Dear Secretary of State,

Snape Parish Council submits the below comments for your information and consideration with regard to the DCO for Scottish Power Renewables (SPR) development of an offshore wind farm and substation (EN 010077/78) Ref 20023749/50.

TITLE
SNAPE MITIGATION SCHEME
(A1094 - FARNHAM ROAD) -
PRELIMINARY DESIGN

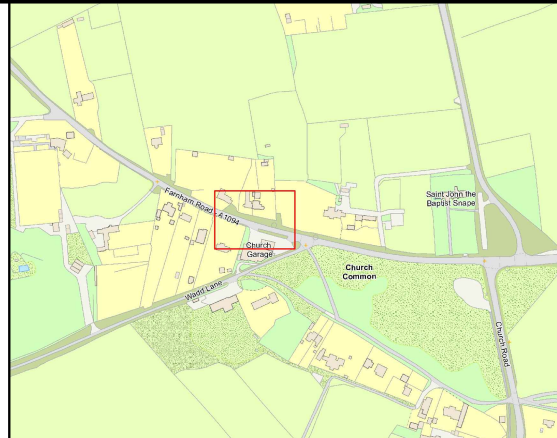
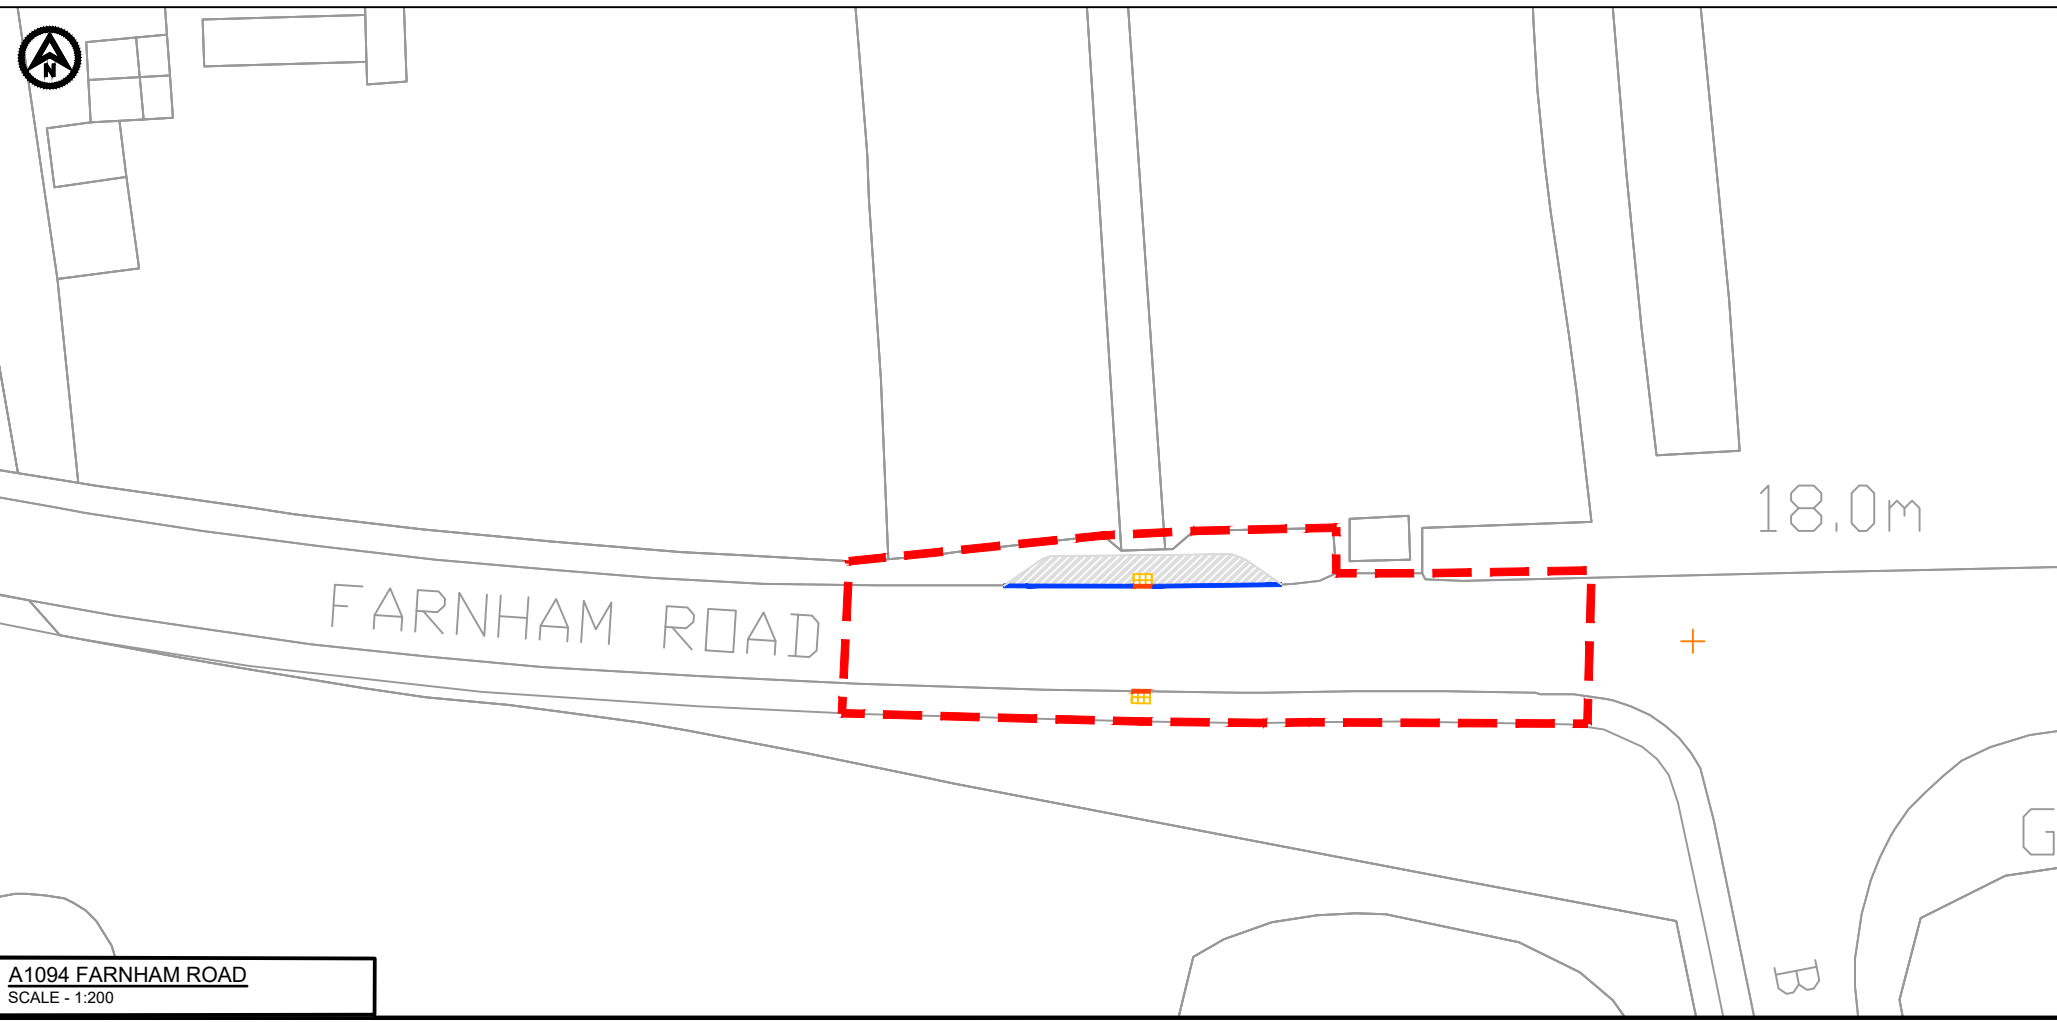
3.2 The DCO response to concerns about access to local facilities such as the local Church sited on the A1094 being accessed from a car park by pedestrians across the main road, an existing traffic hazard, does recognise the issue and offers some mitigation without addressing the underlying issue of increased traffic volumes.
